From: [Chris Cruse](#)
To: [Zach Torrance-Smith](#); sageviewfarm@yahoo.com
Cc: [Jamey Ayling](#); [Ellie Myers](#); [Bradley Gasawski](#)
Subject: RE: SP-25-00002 Sageview - Transmittal of Comments
Date: Monday, February 10, 2025 9:54:52 AM

Subject: SP-25-00002 Sageview - Transmittal of Comments

SAGEVIEW BLA/SHORT PLAT

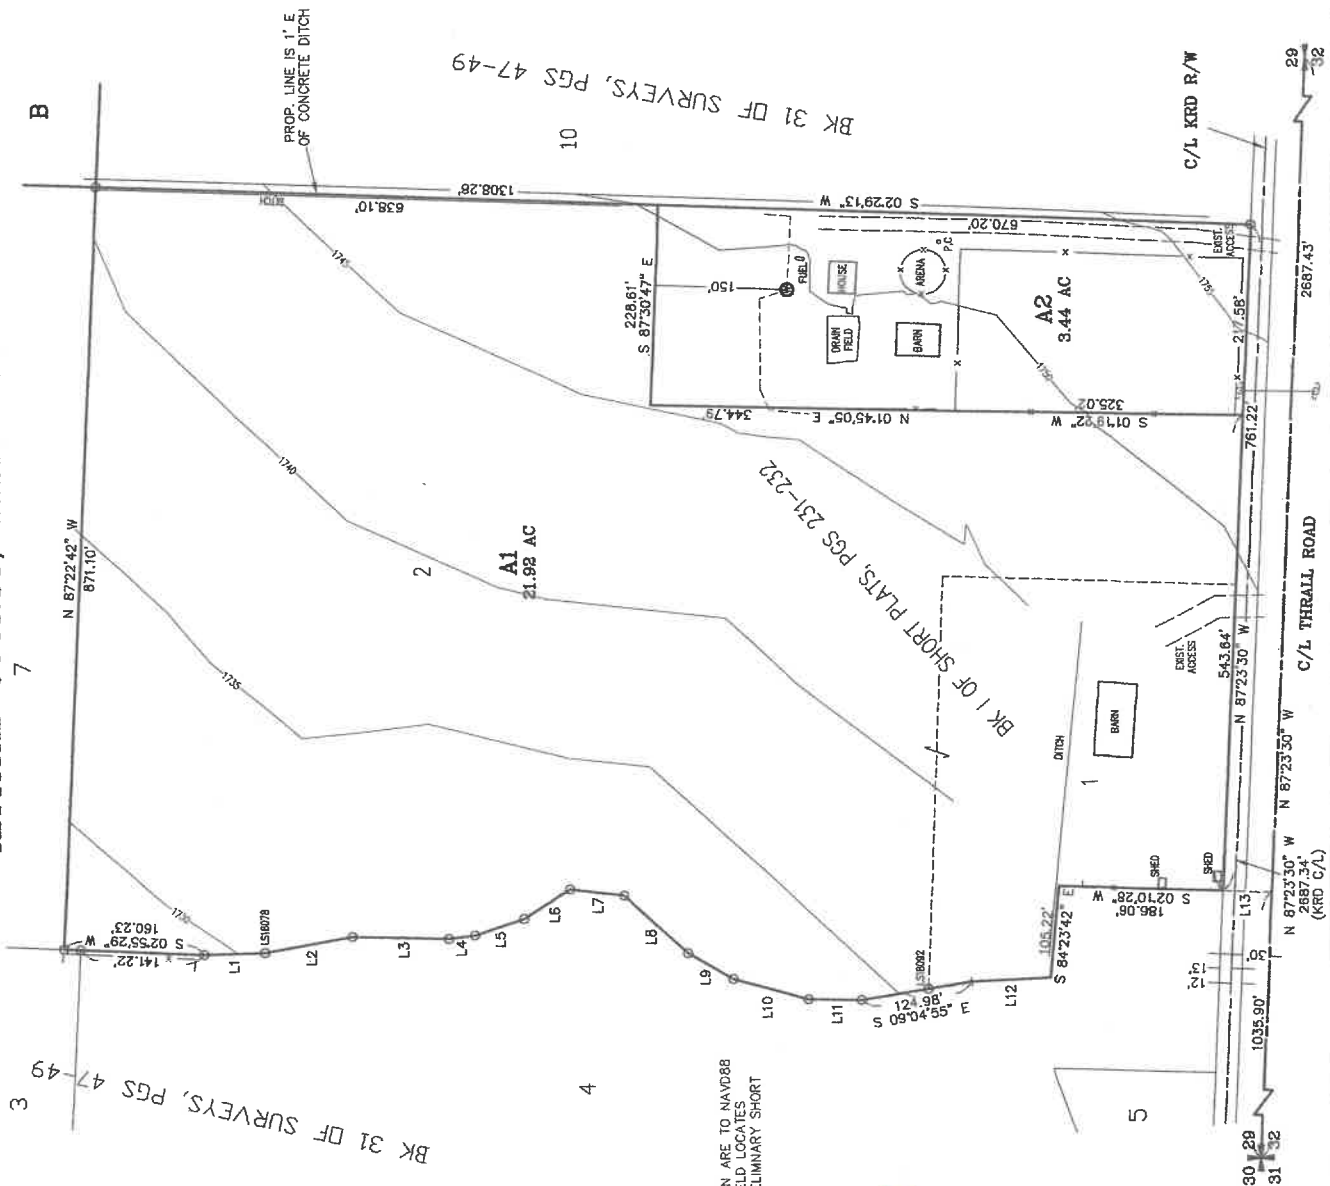
Health - The existing well is 150' from the proposed boundary and labeled on the map. I am not sure what the comment from EH is referring to when they state the well does not meet the required 50' setback but our application does meet all setbacks required under KCC 13.20.040(5)(a).

Public Works - The final mapping for this application will all be recorded with the Auditor in the book of short plats and should not be labeled a boundary line adjustment (BLA) as requested as it will add confusion. I can add notes to clarify but will not appear correct if mapping is labeled as a BLA in the Auditor's book of short plats. I also want to point out comment 3 that states all parcels within this application will be considered a part of the short plat after recording. To clarify proposed parcels B and C shown in this application are existing parcels and included only to show the final configuration. By code parcels B and C are being adjusted as a boundary line adjustment and should be reviewed under KCC 16.10. Parcels B and C should not need to meet KCC 16.32 that has different requirements like purchasing water rights and completing soil logs for final approval. Parcels A1 and A2 on sheet 2 are being subdivided under KCC 16.32 and will need to meet all requirements for a short plat.
